**2025/92776 - Land at, Eastfield, Shepley, Huddersfield, HD8 8HB**

**Outline application, with all matters reserved, for residential development with associated open space, landscaping, drainage infrastructure and associated works**

Project ID: XT12_SLY25
 Survey location showing processed greyscale magnetometer data

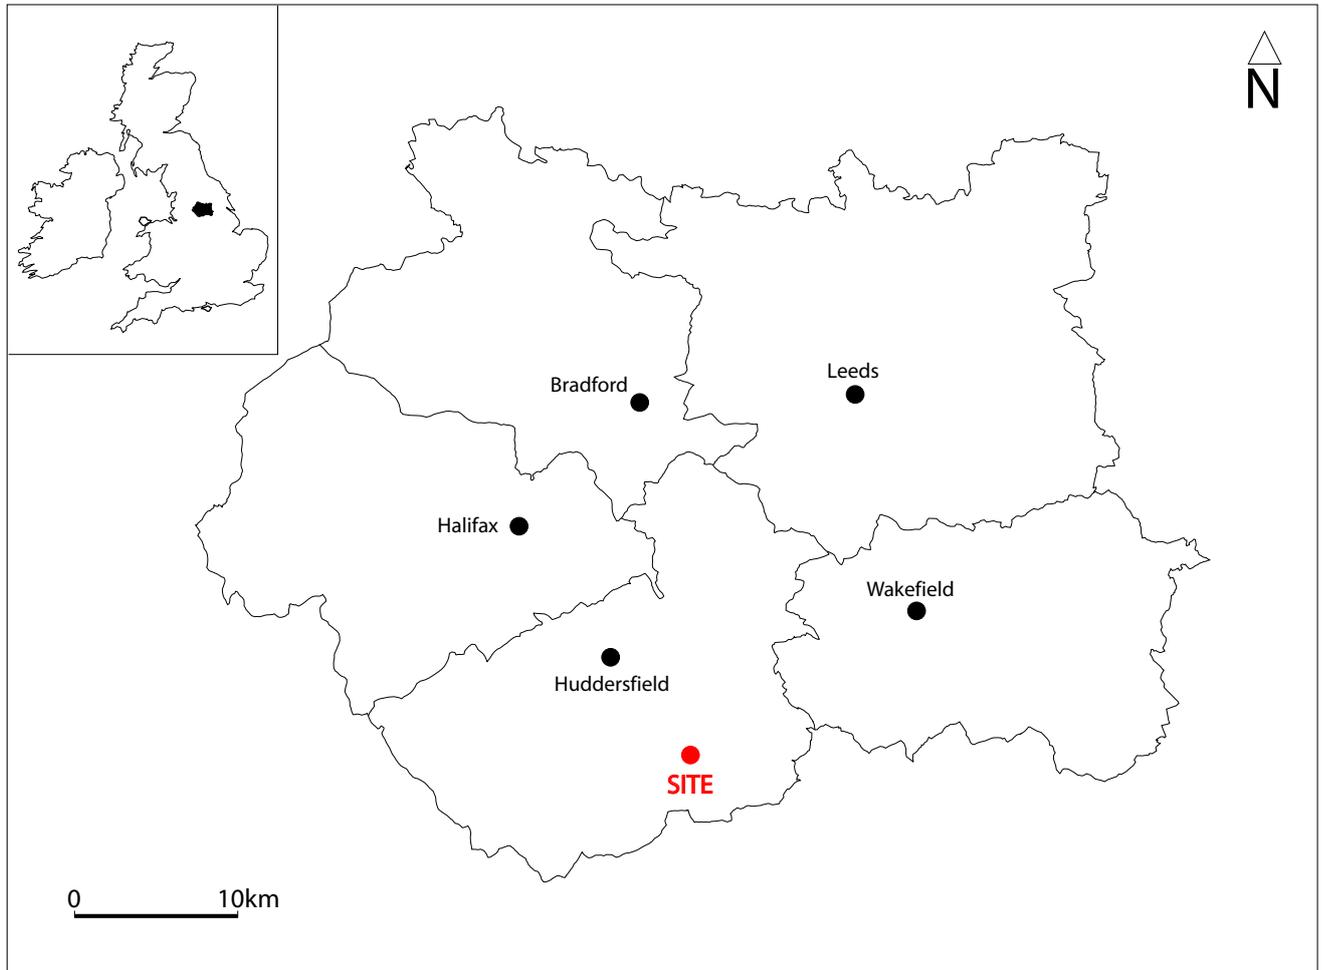
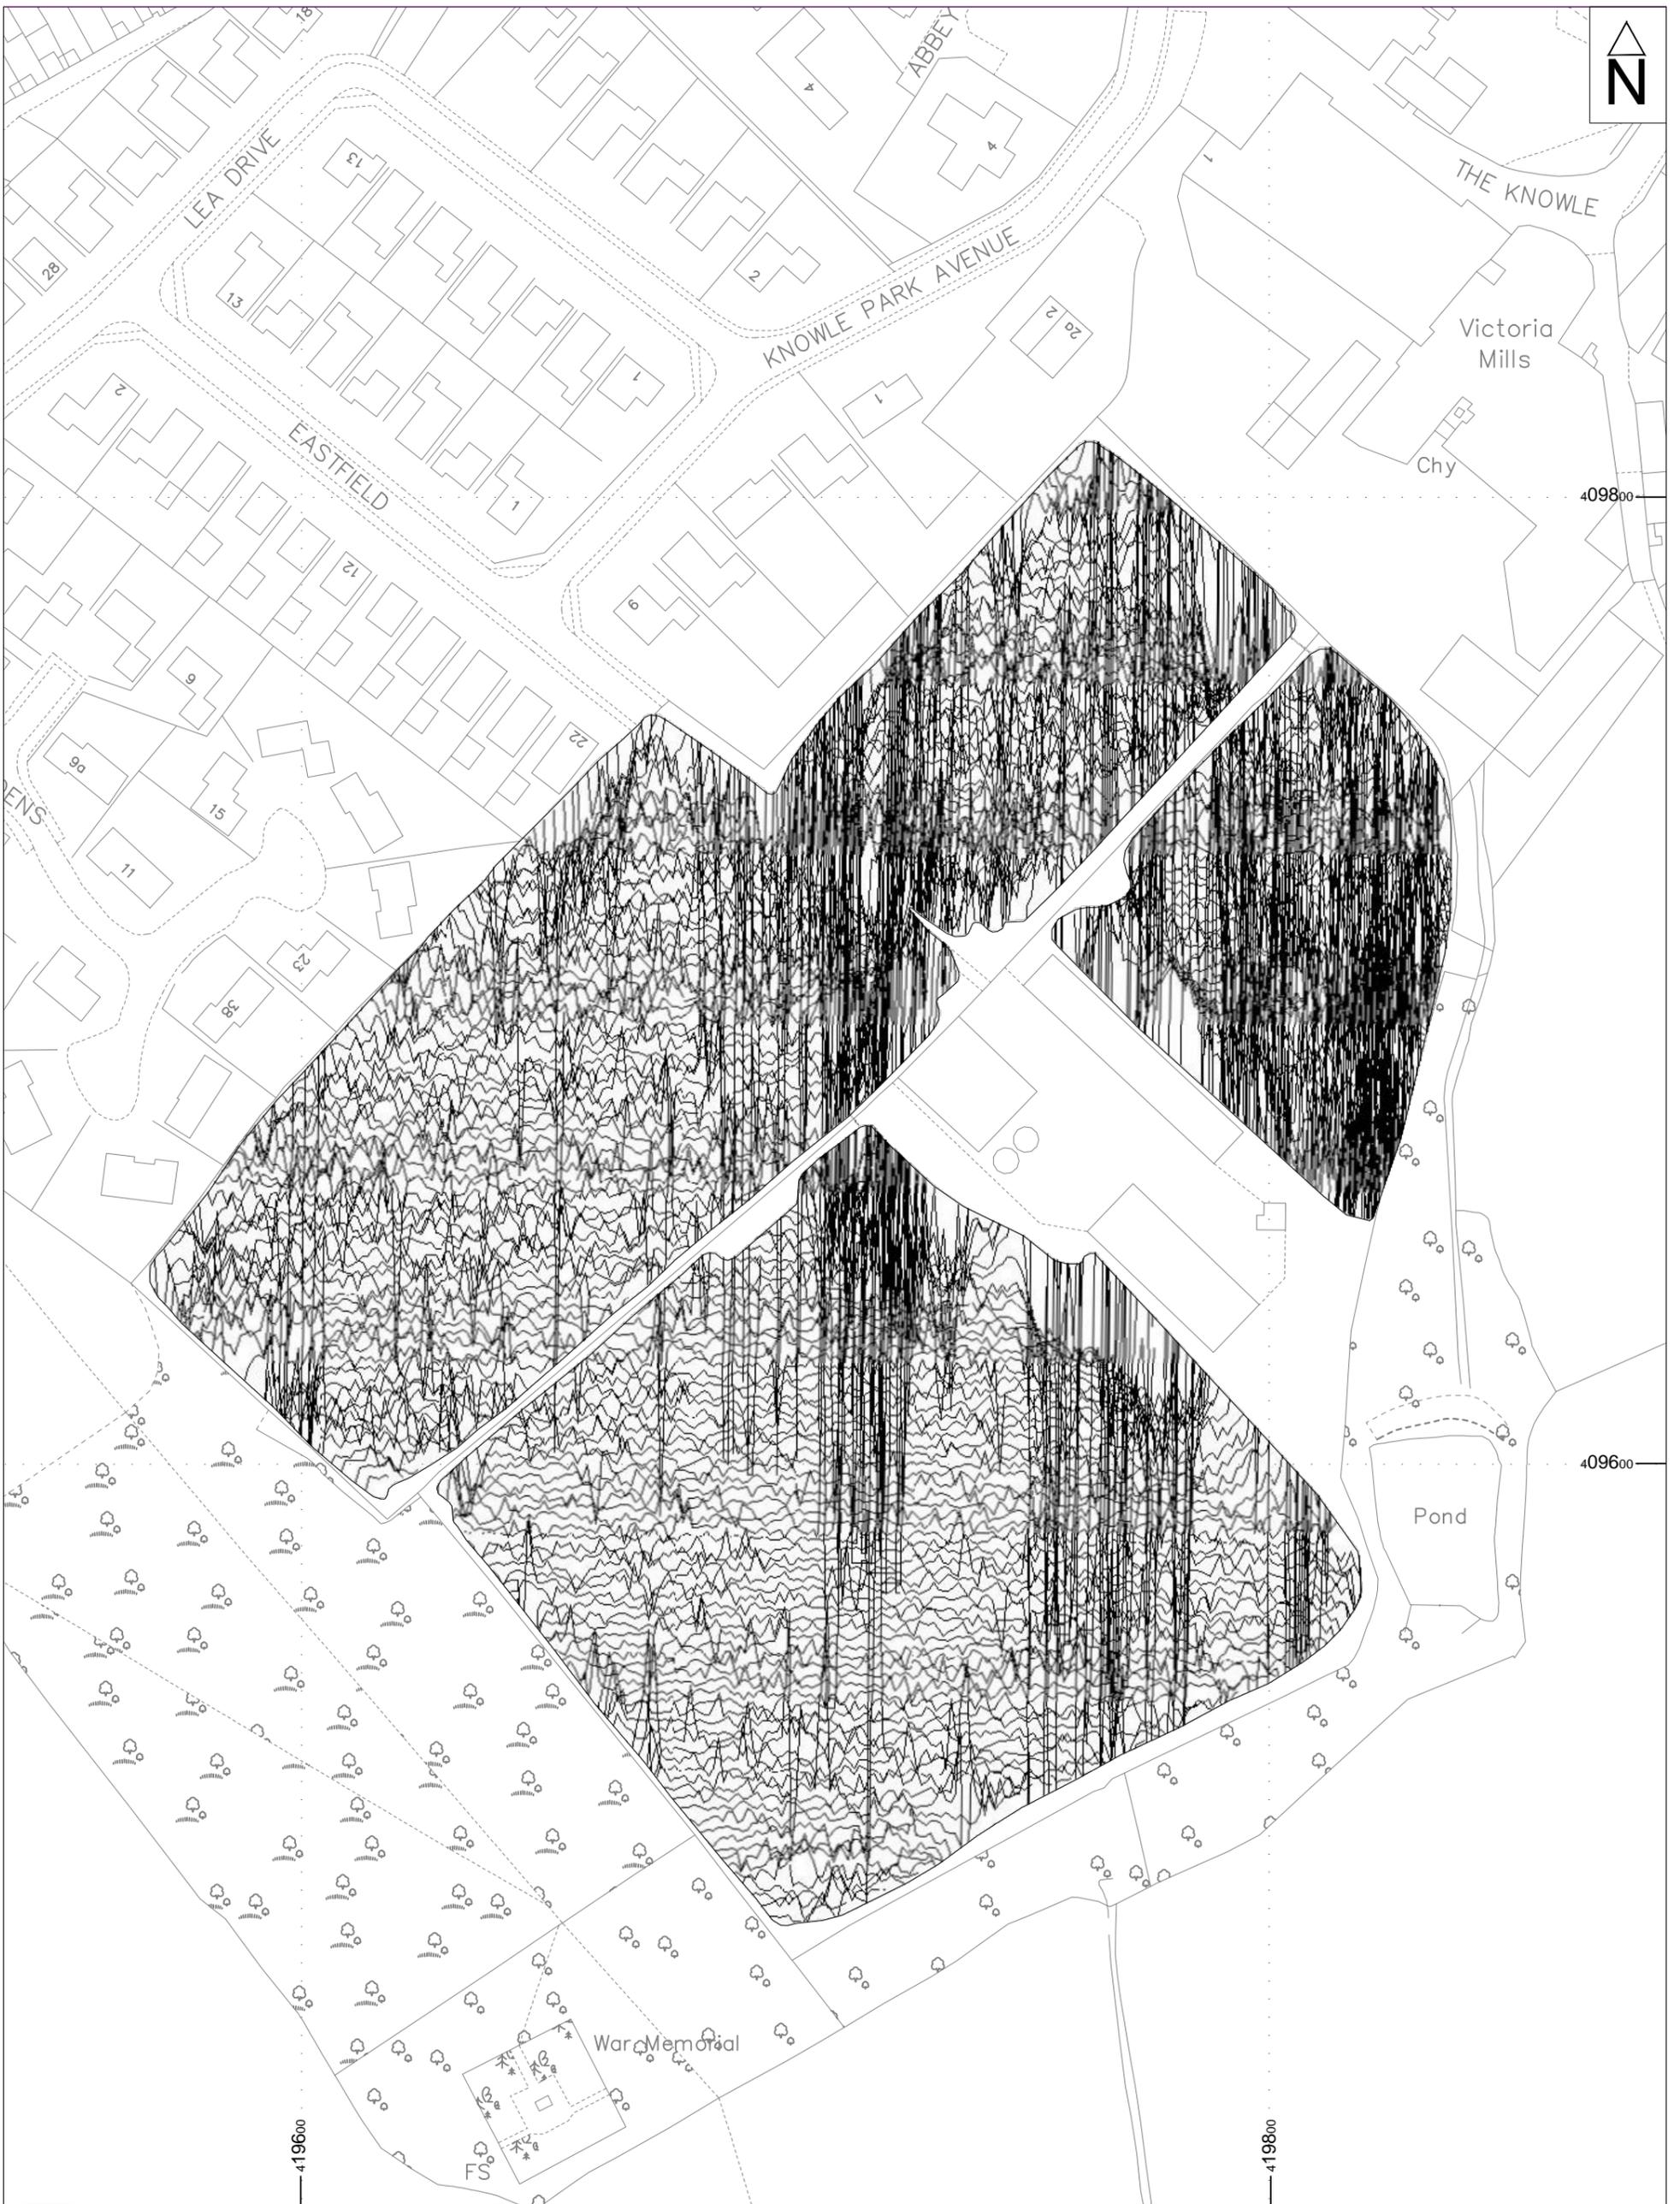
Having reviewed the application and the submitted Heritage Assessment and Geophysical Survey I would suggest that a programme of archaeological fieldwork is undertaken to fully evaluate the proposed development on the archaeology on the site. The geophysical survey had recorded some anomalies that do not appear to match the current field boundaries or ploughing patterns. There are also some areas that are masked by magnetic disturbance which should be tested.

I recommend that a programme of archaeological evaluation by trial trenching should be undertaken to assess the archaeological potential of the site. The date and function of the anomalies should be confirmed. The field evaluation should comprise a programme of trial trenching that would be targeted at anomalies identified by the geophysical survey. This evaluation should be undertaken prior to determining this application so the data from the trial trenching can be used in assessing the significance of the archaeology on site and assessing the impact of the proposed development on that archaeology.

“No demolition/development shall take place/commence until a written scheme of archaeological investigation (WSI) has been [submitted to and] approved by the local planning authority in writing. For land that is included within the WSI, no demolition/development shall take place other than in accordance with the agreed WSI, which shall include the statement of significance and research objectives, and
